**RE: TAPIA LAW OFFICE (J14-D117). GRADING AND DRAINAGE PLAN
SUBMITTAL FOR PRELIMINARY PLAT, FINAL PLAT, AND BUILDING
PERMIT. ENGINEER'S STAMP DATED MARCH 7, 1997.**

**RE: TAPIA LAW OFFICE (J14-D117). GRADING AND DRAINAGE PLAN
SUBMITTAL FOR PRELIMINARY PLAT, FINAL PLAT, AND PRELIMINARY
PLAT APPROVALS. ENGINEER'S STAMP DATED FEBRUARY 25, 1997.**

RE: TAPIA LAW OFFICE (J14-D117). GRADING AND DRAINAGE PLAN
SUBMITTAL FOR PRELIMINARY PLAT, SITE DEVELOPMENT (FOR BUILDING
PERMIT), AND FINAL PLAT APPROVAL. ENGINEER'S STAMP DATED
FEBRUARY 4, 1997.

GRADING AND DRAINAGE PLAN
SCALE: 1" = 20'-0"

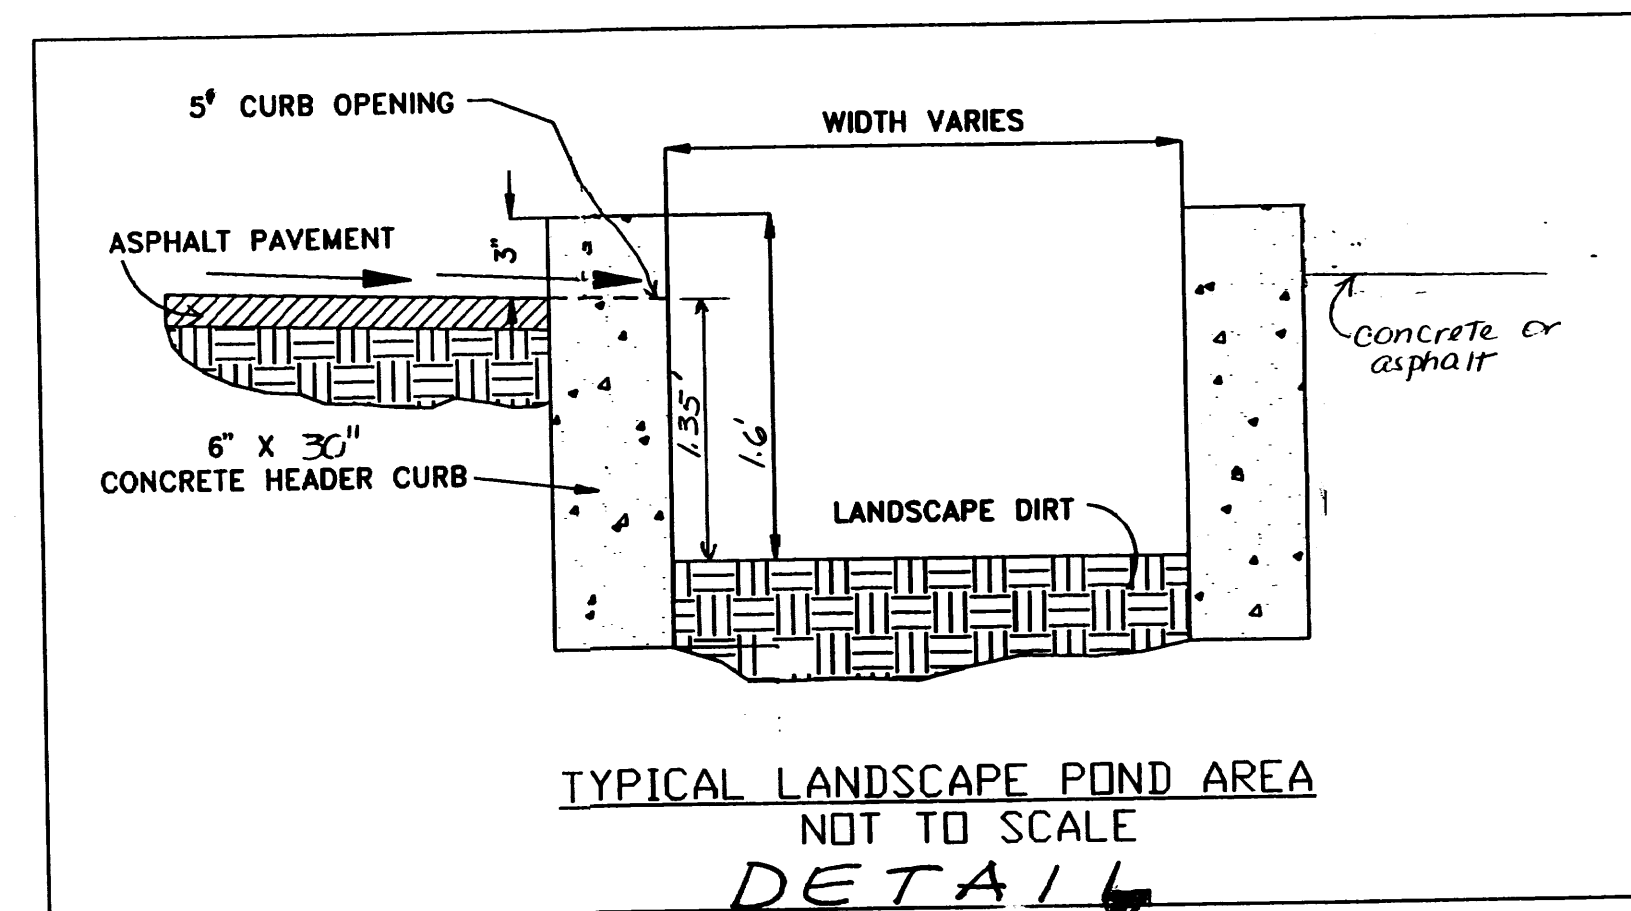
1. Simply stating that you will pond in the landscaped areas
is too vague. Show pond elevations and exact locations.

GRADING AND DRAINAGE PLAN
 SCALE: 1" = 20'-0"

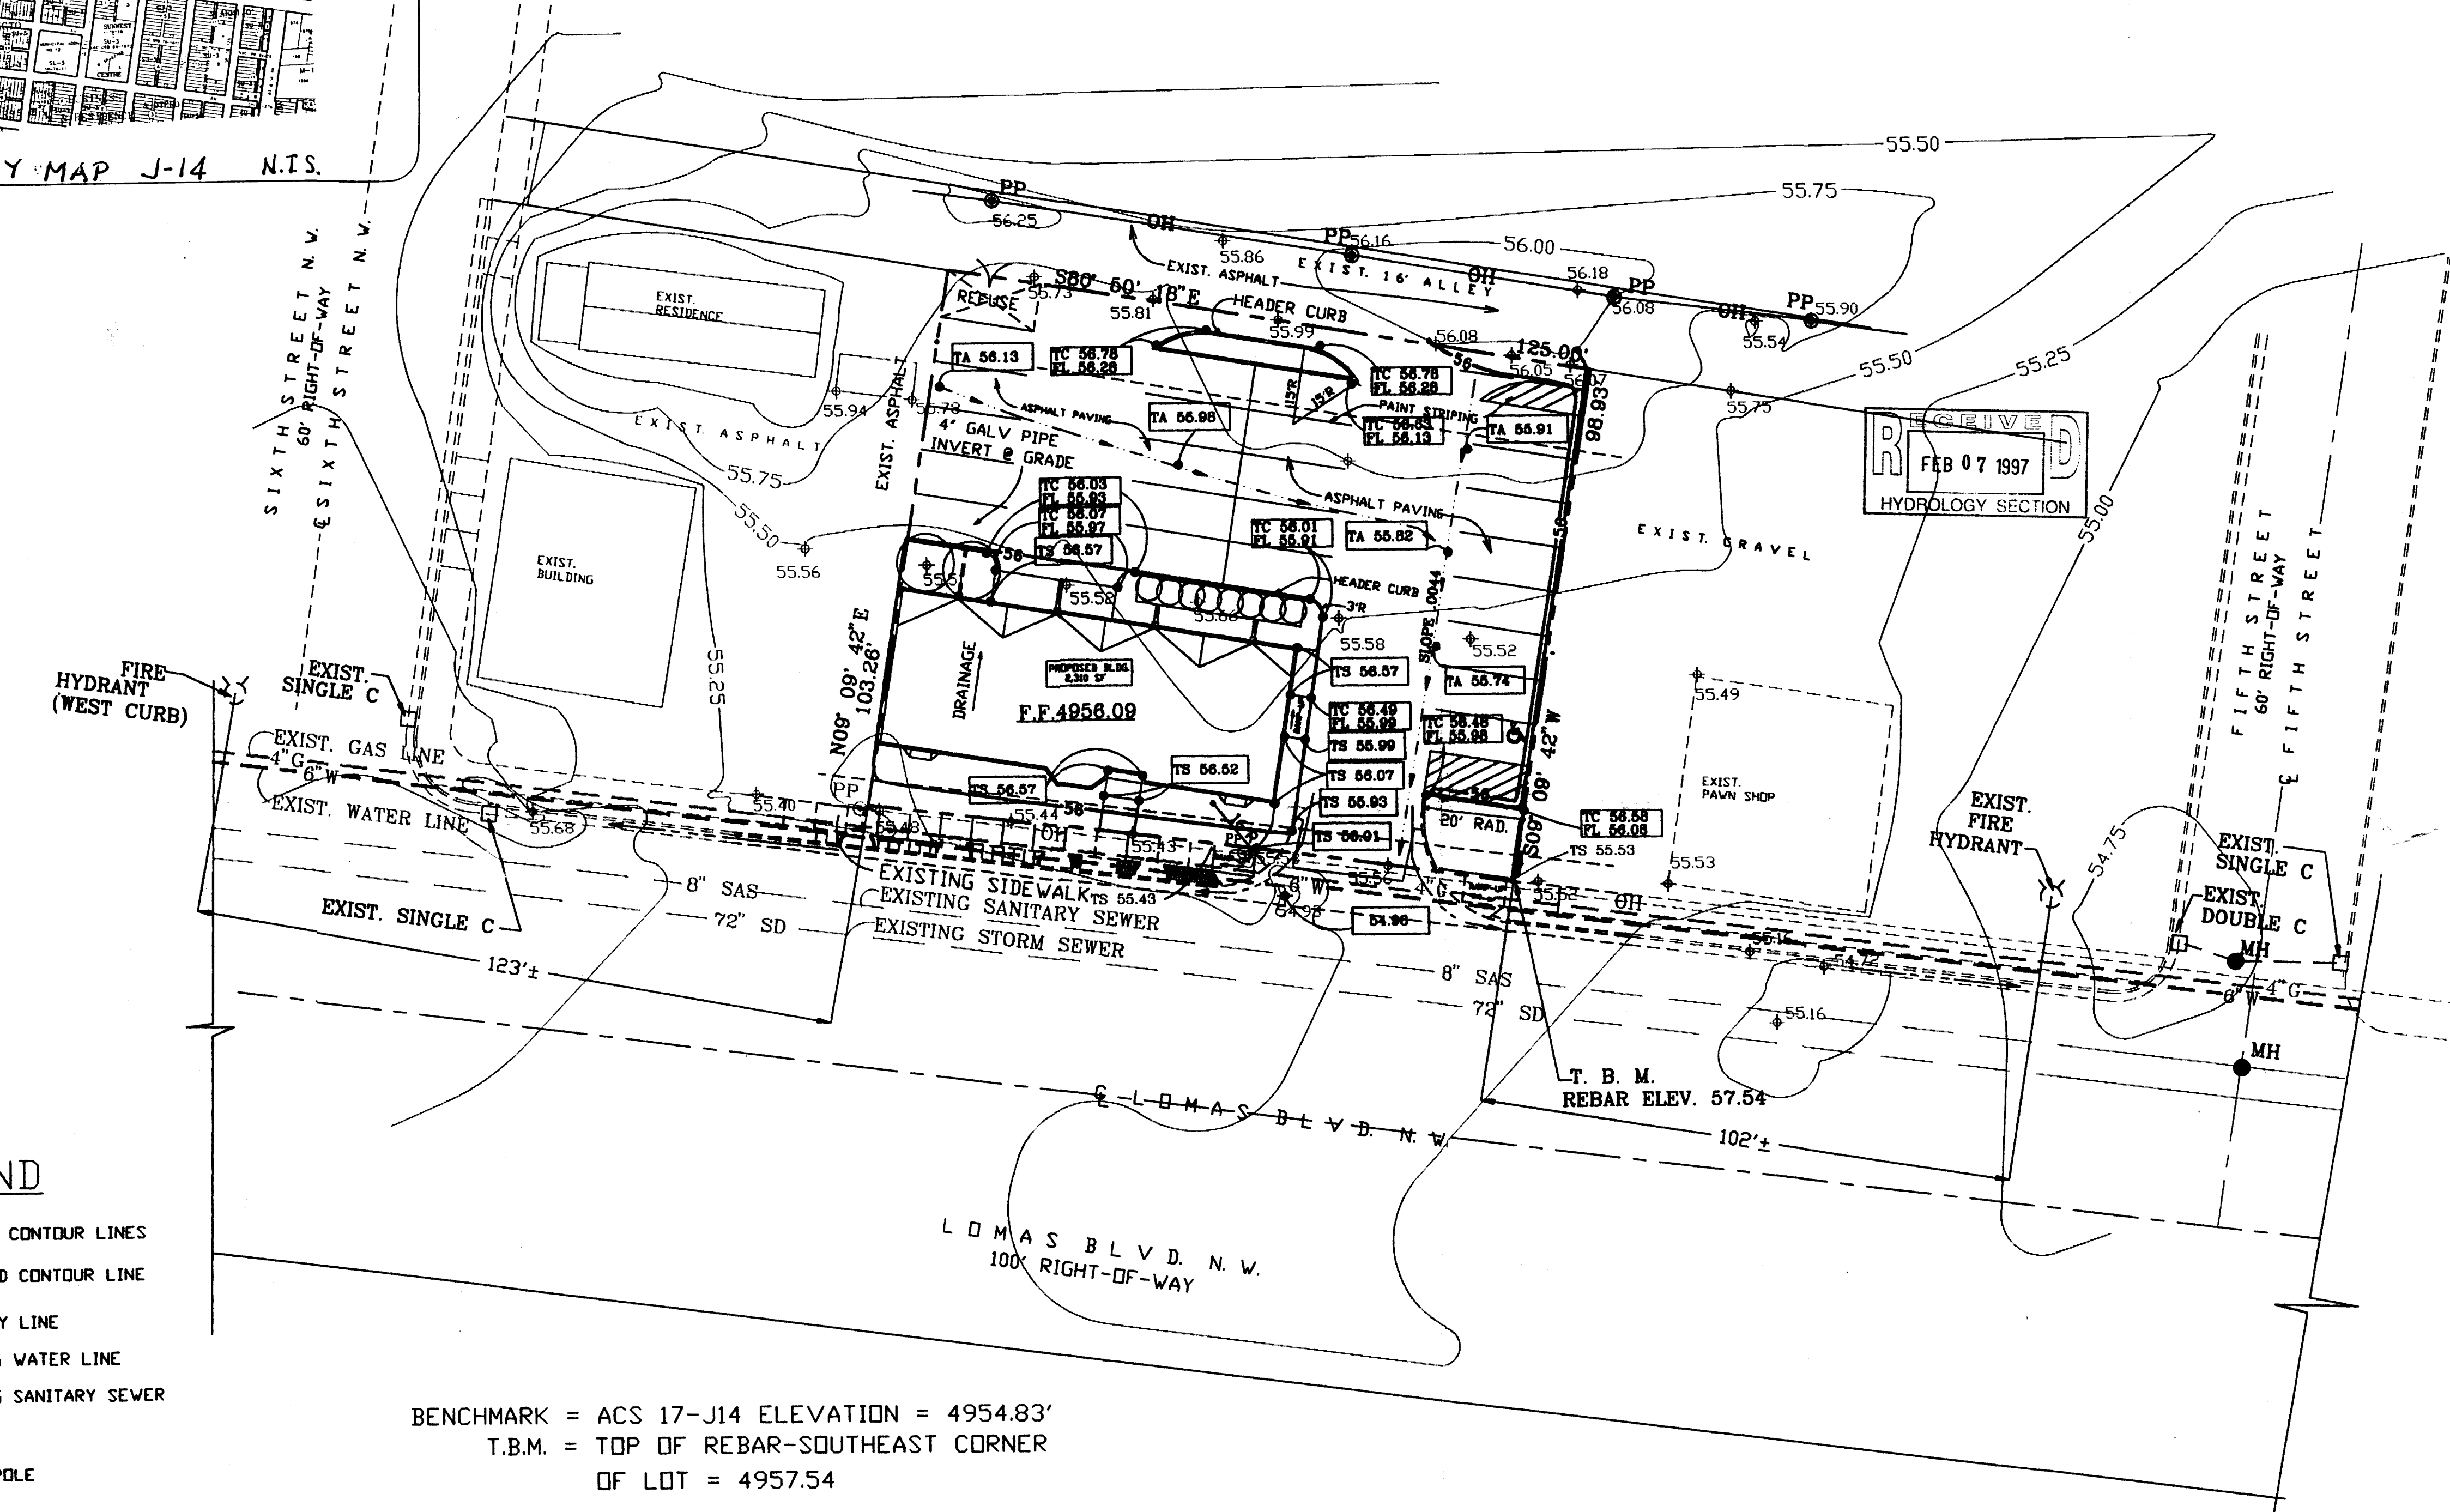
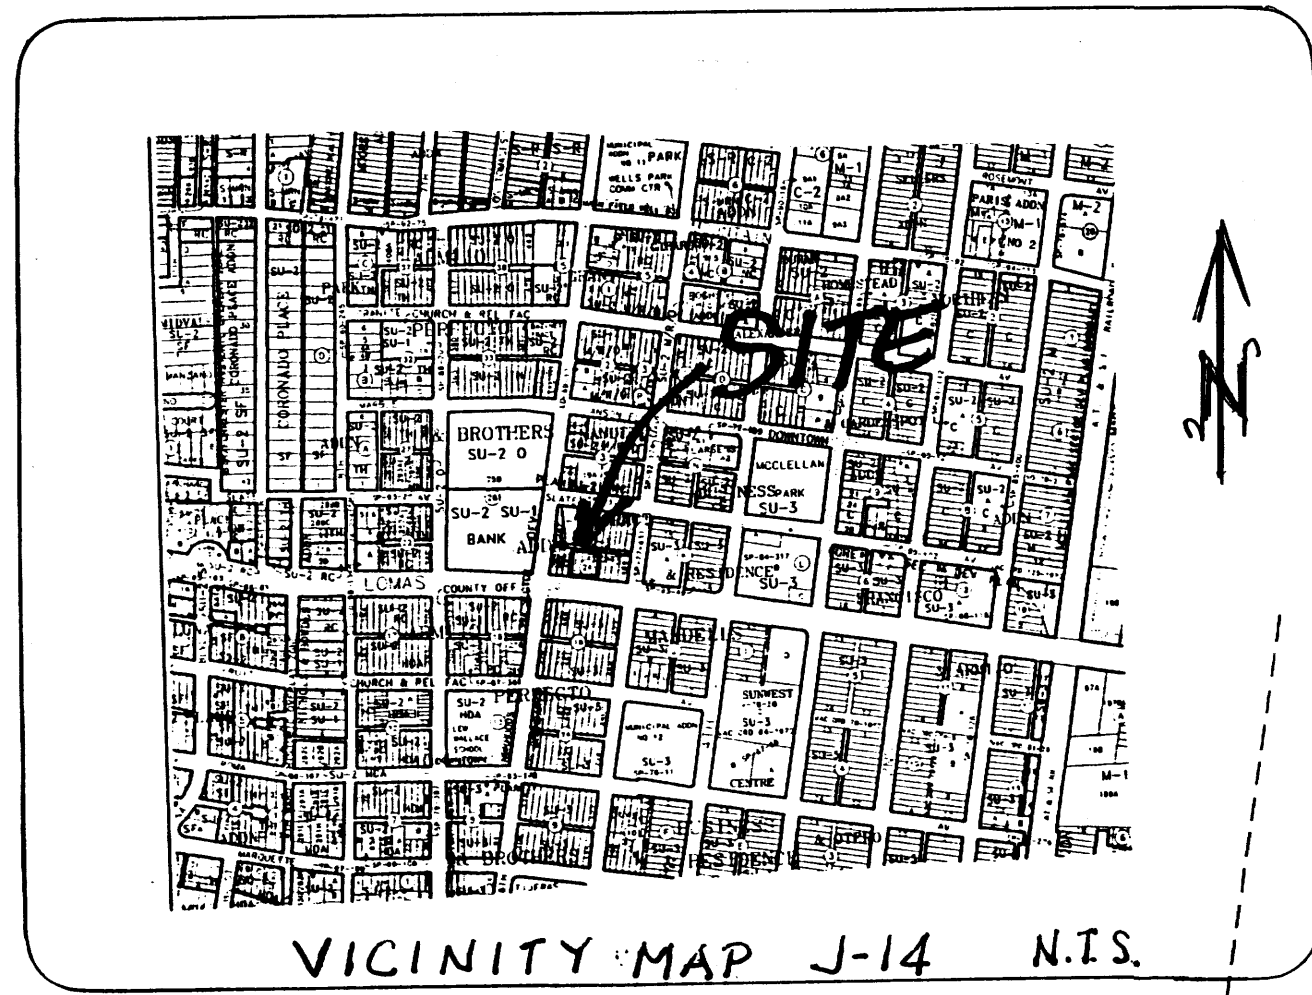
1. You will be required to pond the 0.55 cfs increase in flow
per the pre-design conference requirements.
2. Indicate the required 1-foot water block at the driveway.
3. Provide a copy of the proposed plat and a DRB number.

- DONE** 1. You will be required to pond the 0.55 cfs increase in flow
per the pre-design conference requirements.
- SHOWN** 2. Indicate the required 1-foot water block at the driveway.
- ATTACHED** 3. Provide a copy of the proposed plat and a DRB number.
